TO: Maxx Oliver, CZO – Entitlement Services
FROM: Tolu Ibikunle, AICP – Long Range Planning
SUBJECT: REZ 2024-066: 2040 Comprehensive Plan Consistency
LOCATION: 11111 Carmel Commons Boulevard (PID: 22144103)
DESCRIPTION: Zoning Change Request from **B-1SCD** to **CAC-1(CD)** -- 1.98 acres.

SITE PLAN

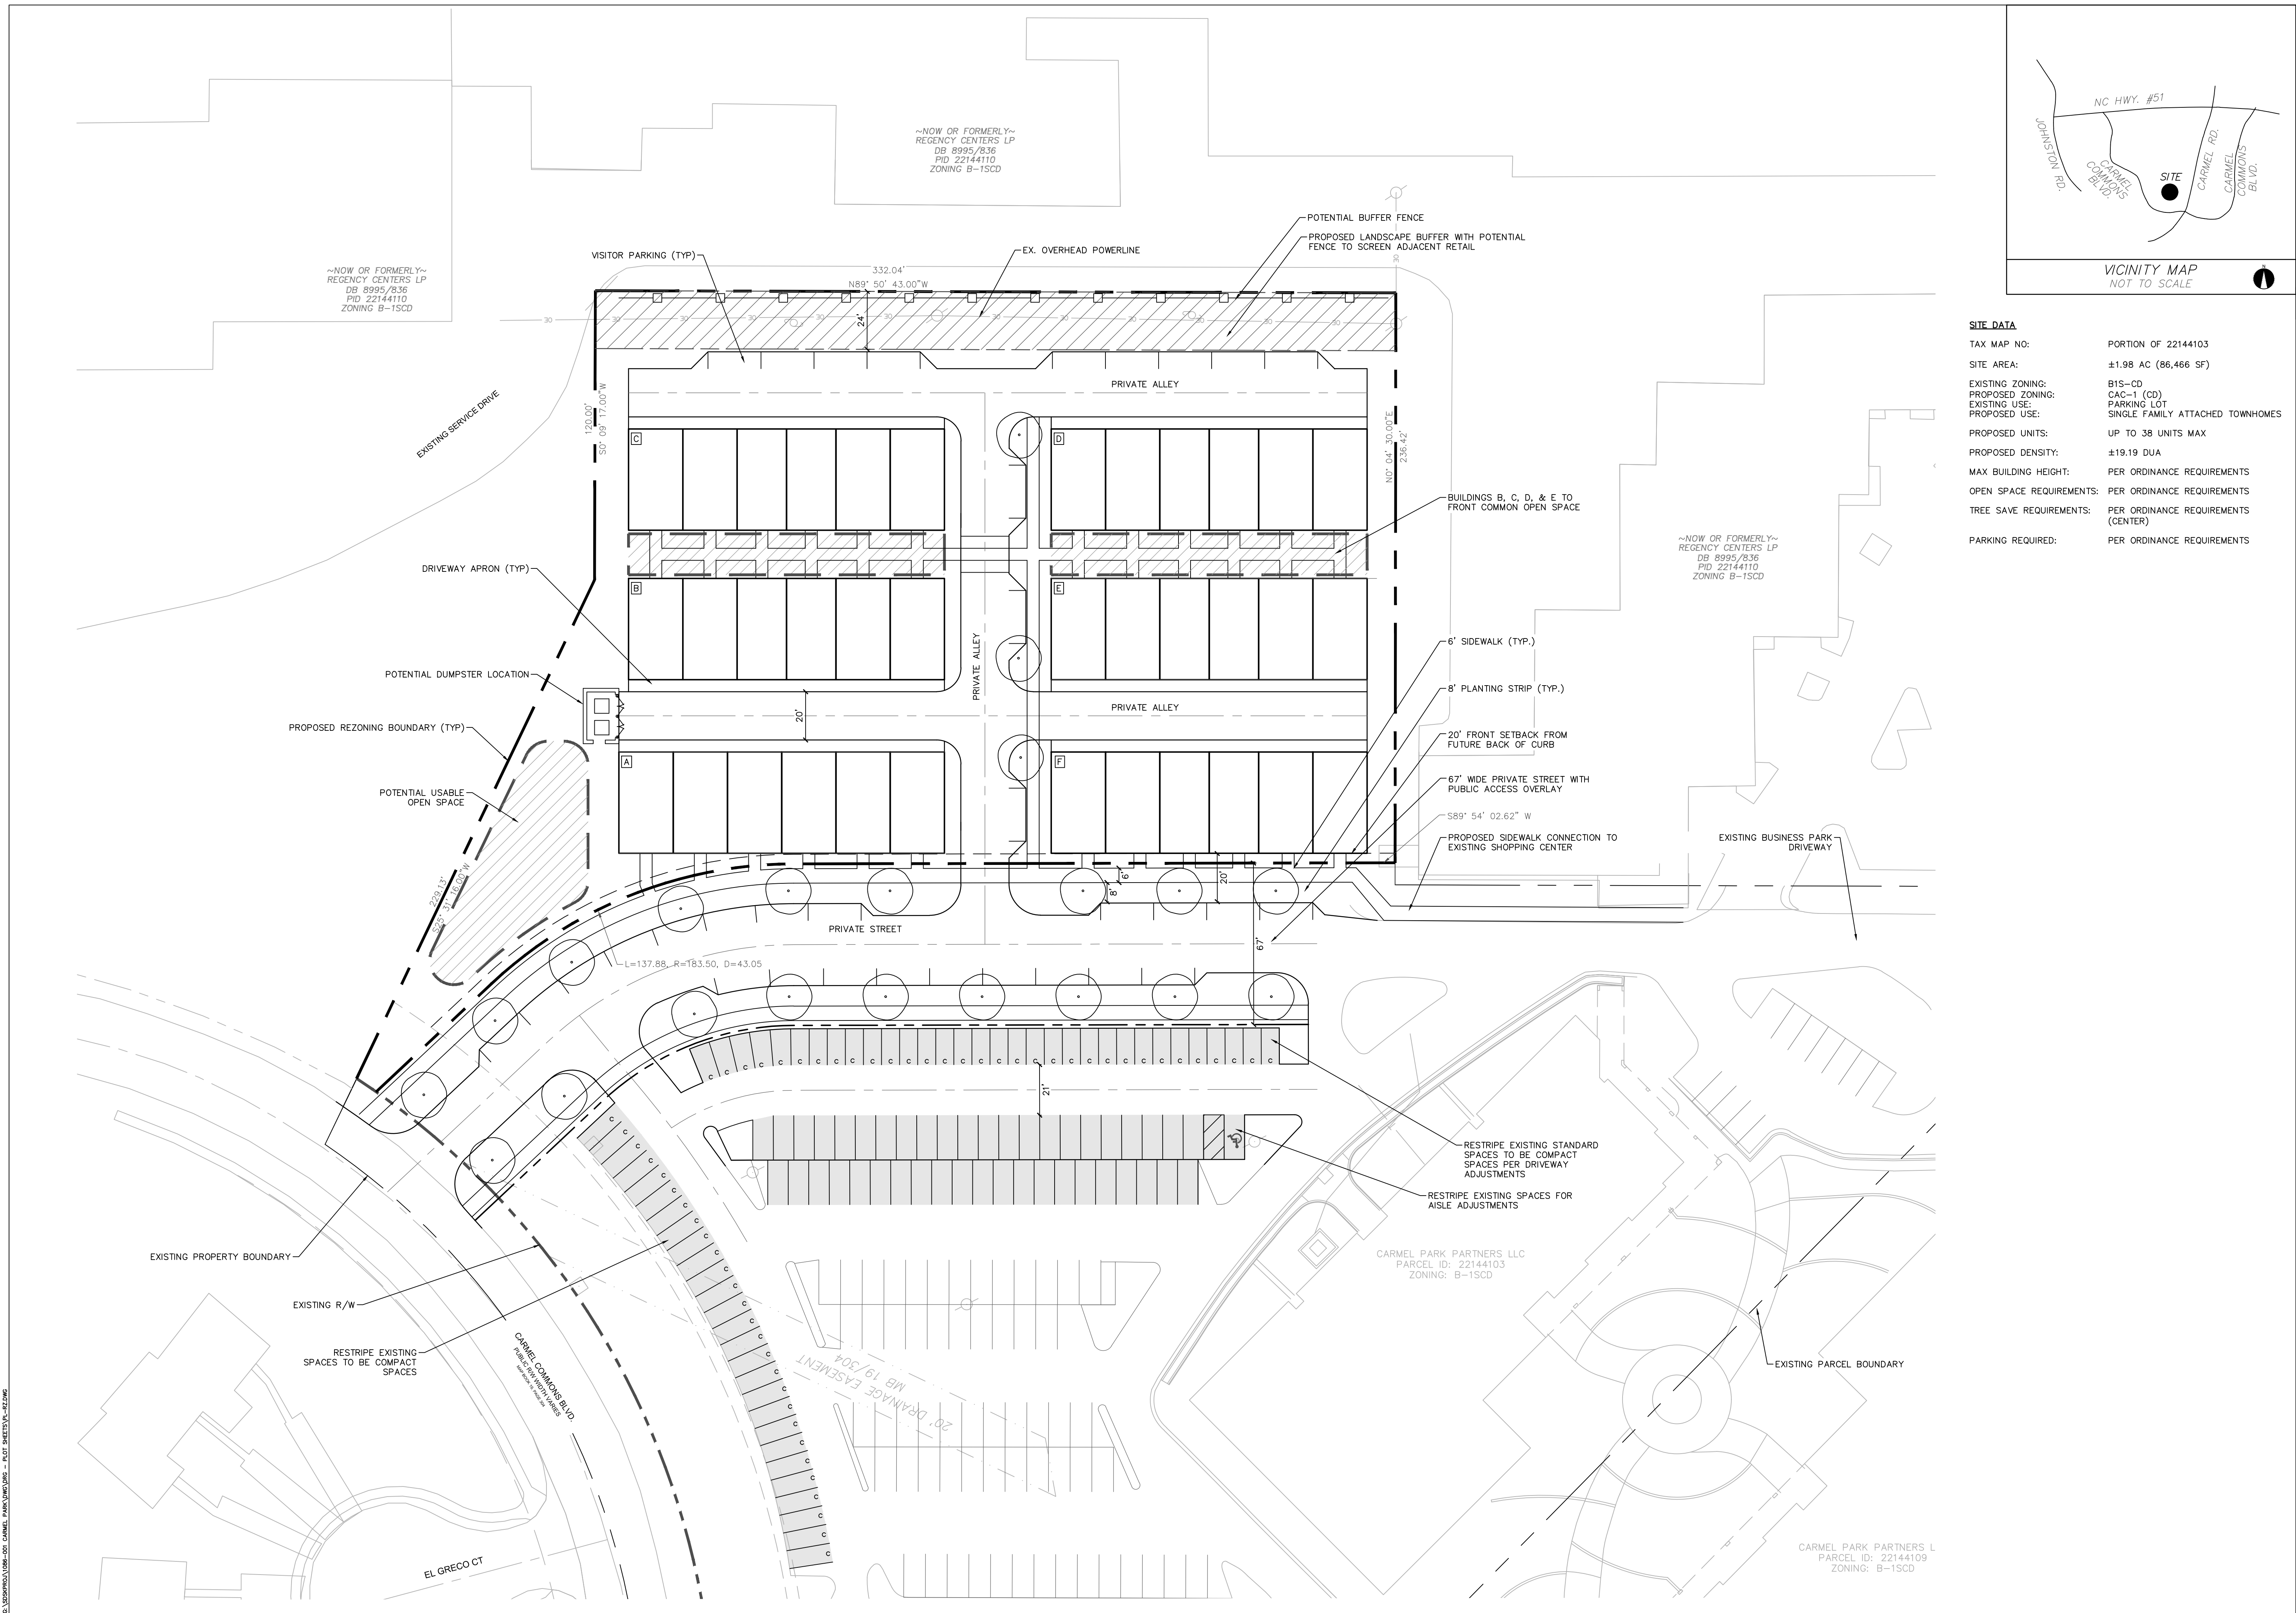
<p>BUILDING FORM</p>	<p>Commercial, institutional, multi-family or mixed-use buildings of 5 to 7 stories (taller near transit). Buildings are designed with active ground floor uses to support a vibrant pedestrian environment. They have tall ground floors and a high degree of transparency using clear glass windows and doors.</p>	<p><i>The petition is for up to 38 townhomes and does not include multi-story buildings with active ground uses and residential or another use on top. Furthermore, the proposed townhomes front the rear of stores where dumpsters are located and waste management and delivery trucks use.</i> The rear of the subject site includes 30’ landscape buffer with an 8’ fence. The eastern part of the site abutting back of house uses and the western side will include a 10’ landscape buffer. <i>These proposed treatments will not adequately screen those uses. Developing townhomes abutting back of house uses does not align with the spirit of CAC.</i></p>

<p>OPEN SPACE</p>	<p>Improved open space is a key feature, such as, plazas, patios, and courtyards that may include landscaping. Public open spaces such as small parks and greenways, and natural open spaces such as tree preservation areas, are also an important feature.</p>	<p>The petition <i>only includes a small section of “potential open space” and does not meet the intent of useable open space.</i></p>

<p>Goal 1: 10-Minute Neighborhoods – All Charlotte households should have access to essential amenities, goods, and services within a comfortable and tree-shaded 10-minute walk, bike, or transit trip by 2040.</p> <p><i>The petition features townhomes within a shopping center and in theory is consistent with this goal. However, townhomes abutting back of house uses where residents can view dumpsters and the delivery of goods to retailers is not the intent of this goal. Additionally, the petition does not contribute to a safe or comfortable walk to essential goods and services. It promotes pedestrian activity in back of house uses where people should not walk to access goods and services due to the frequent use by delivery and waste management trucks.</i></p>
	<p>Goal 2: Neighborhood Diversity & Inclusion – Charlotte will strive for all neighborhoods to have a diversity of housing options by increasing the presence of middle density housing (e.g. duplexes, triplexes, fourplexes, townhomes, accessory dwelling units, and other small lot housing types) and ensuring land use regulations allow for flexibility in creation of housing within existing neighborhoods.</p> <p><i>Constructing housing next to back of house uses is not the intent of this goal.</i></p>
